Please ask for: Mrs D Johnson
Email: daun.johnson@arun.gov.uk
Telephone: 01903 737762
Our Ref: BR/190/20/OUT
Your Ref:
Date: 18th August 2020

Application for Outline Planning Permission

Development: 10 new dwellings consisting of 1 No. 1 bed property, 8 No. 2 bed properties & 1 No. 4 bed property with associated services, landscaping, car parking & amenity (resubmission following BR/49/20/OUT).
Location: 26 Burnham Avenue Bognor Regis PO21 2JU

SITE PLAN (PROPOSED) 1:200

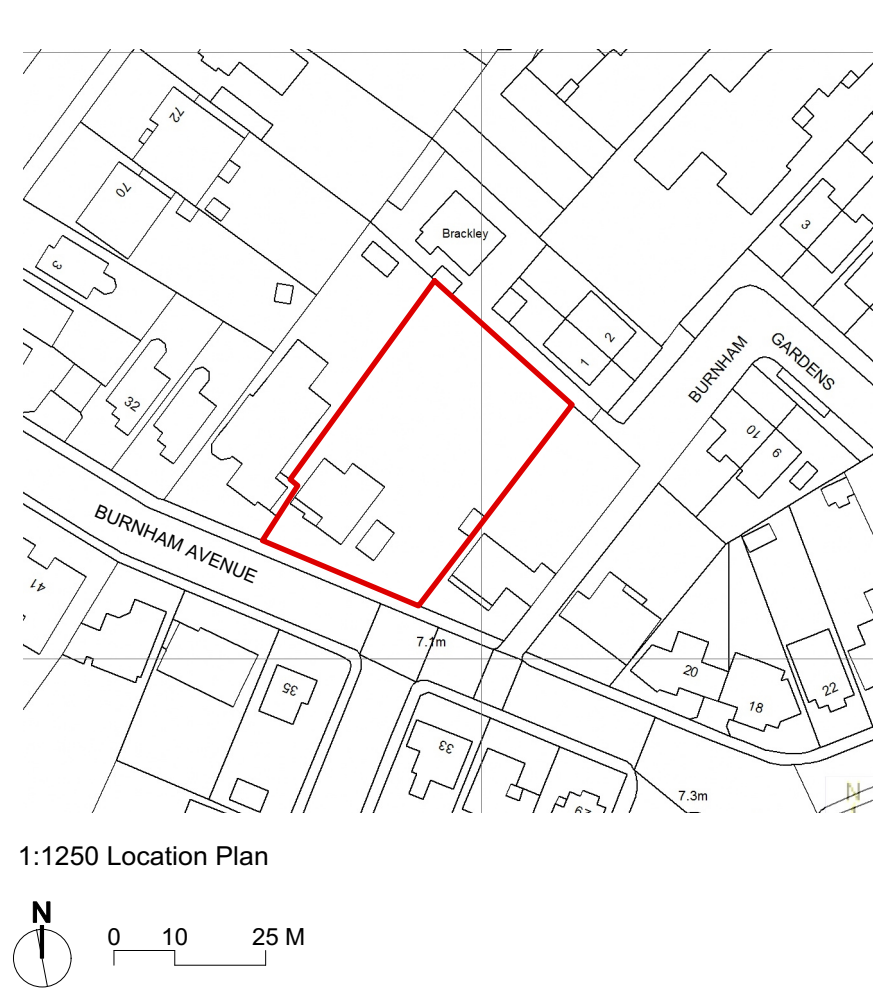
On the site plan, please provide visibility splays for the enlarged dropped kerb.
